Please ask for: Nicola Moore
Email: nicola.moore@arun.gov.uk
Telephone: Ext 37944
Our Ref: A/122/21/PL
Your Ref:
Date: 10th June 2021

Application for Planning Permission

Development: Erection of temporary marguee (21m x 9m x 4m high) for social and leisure use.
Location: Angmering School

D R G
 S C A L F
 D A T F
 2 1 / 1 2 / 1
 1 M A Y 0 M 2 1

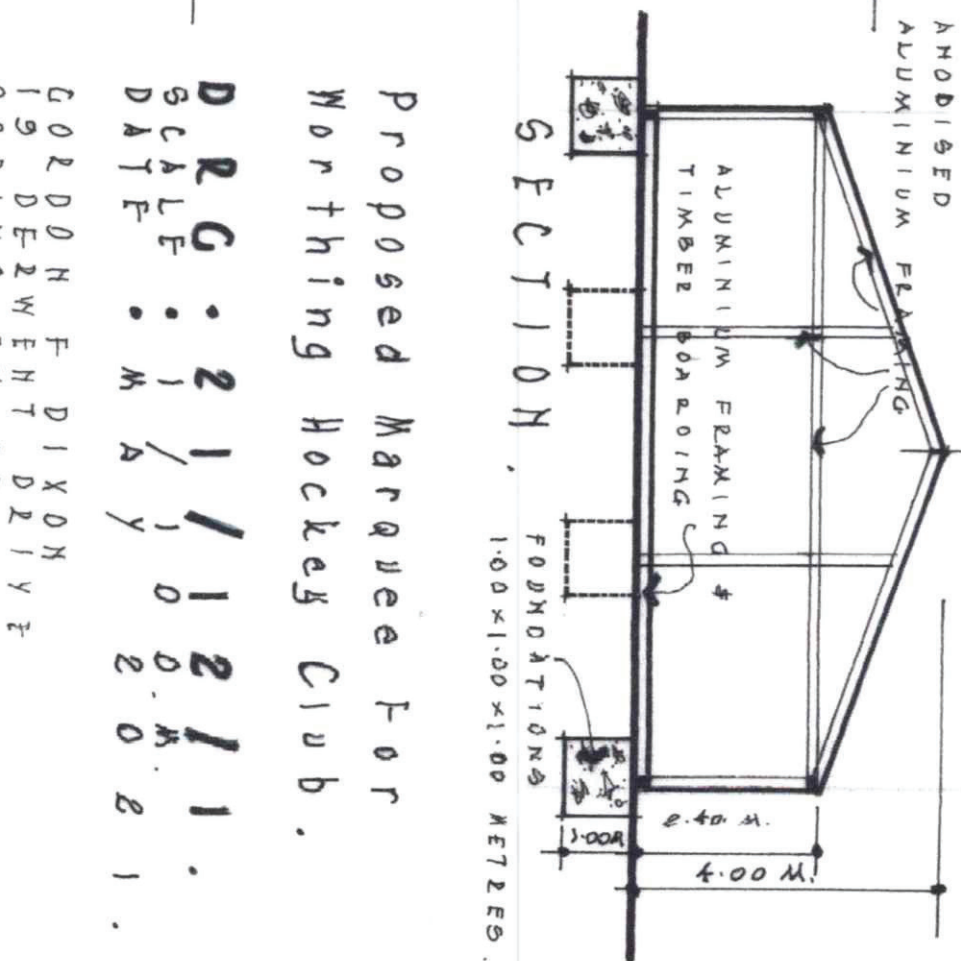
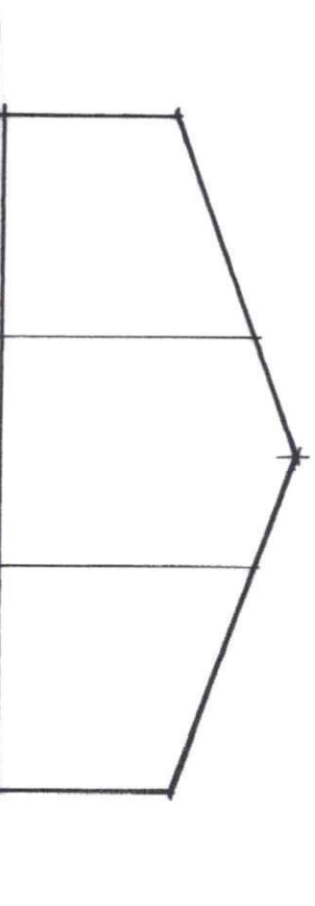
The Block Plan Dwg No 21/12 shows scales of 1:100 and 1:200. Please amend accordingly and re submit.
